Our ref: NO/2012/104338/01-L01
Your ref: 3/2012/0797
Date: 08 October 2012

**PROPOSED STATIC CARAVAN / LODGE PARK
LAND AT SOUTHPORT HOUSE, SAWLEY**

Map 1 Extended Phase 1 Habitat Survey

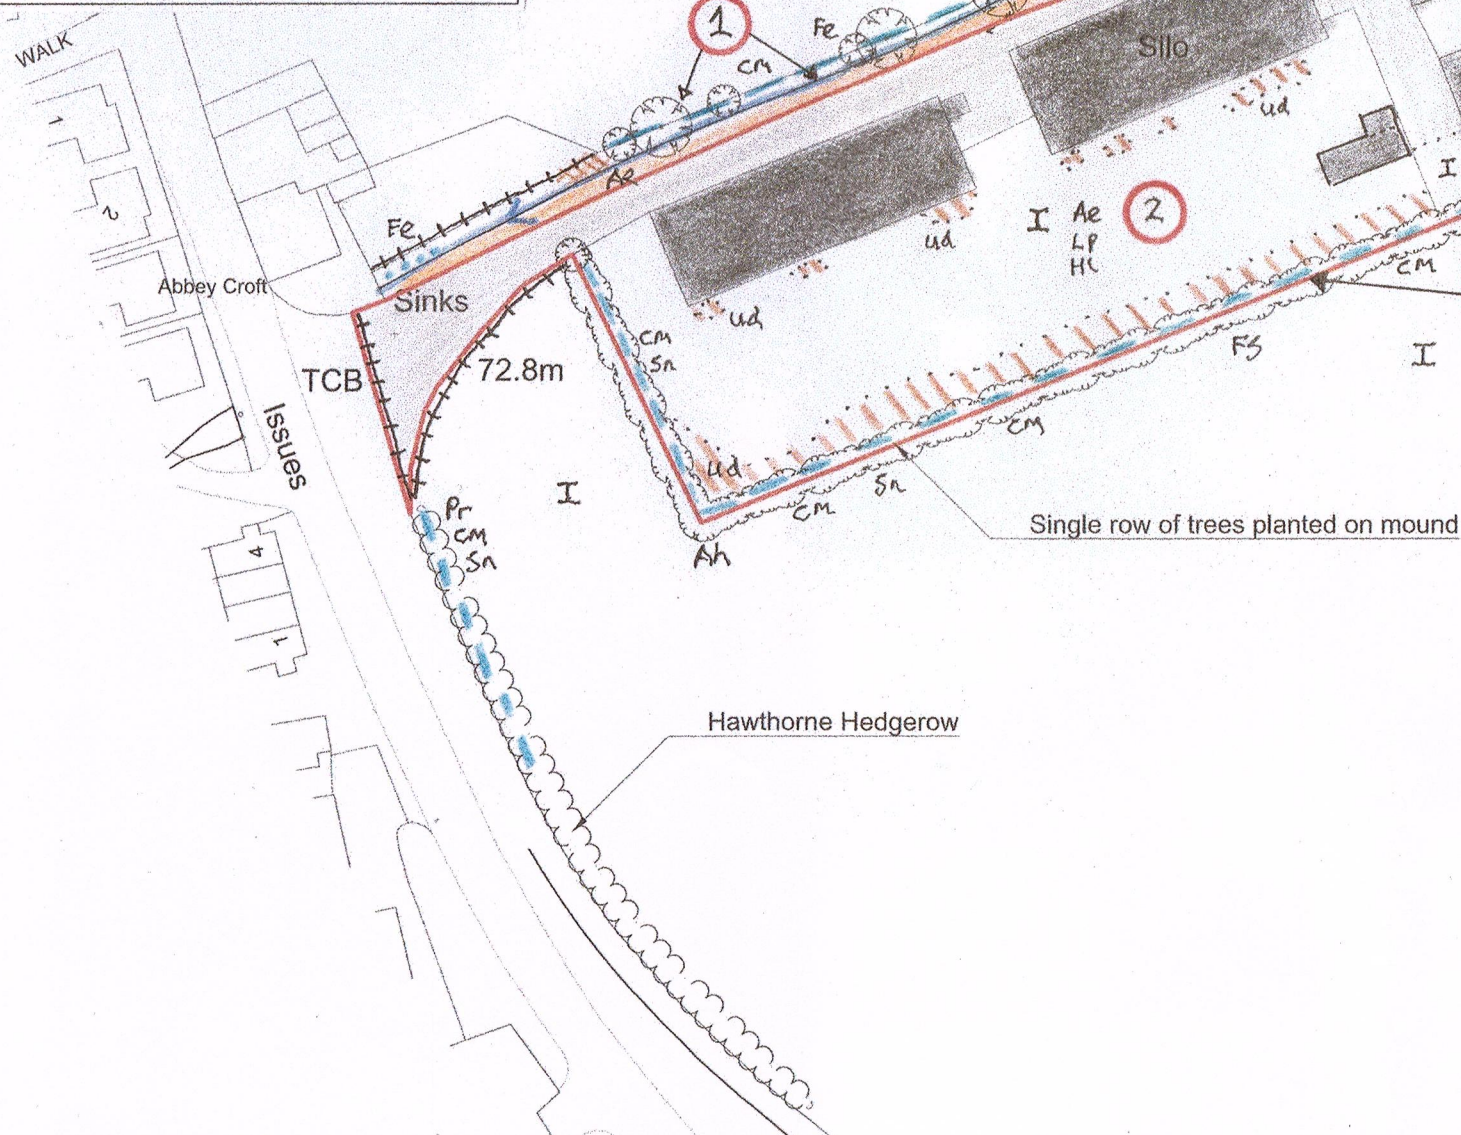
Hollins Syke watercourse flows to the northern boundary of the site, but falls outside the red-edge boundary of the planning application. The watercourse is within 5 metres of the site with a narrow buffer strip of at least 1.5 metres between the watercourse and the application boundary (the existing access track). As the existing access track is to be retained but will not encroach any further towards the watercourse, the developer should ensure that the scheme does detrimentally impact upon the existing buffer strip and that the watercourse is protected during development.
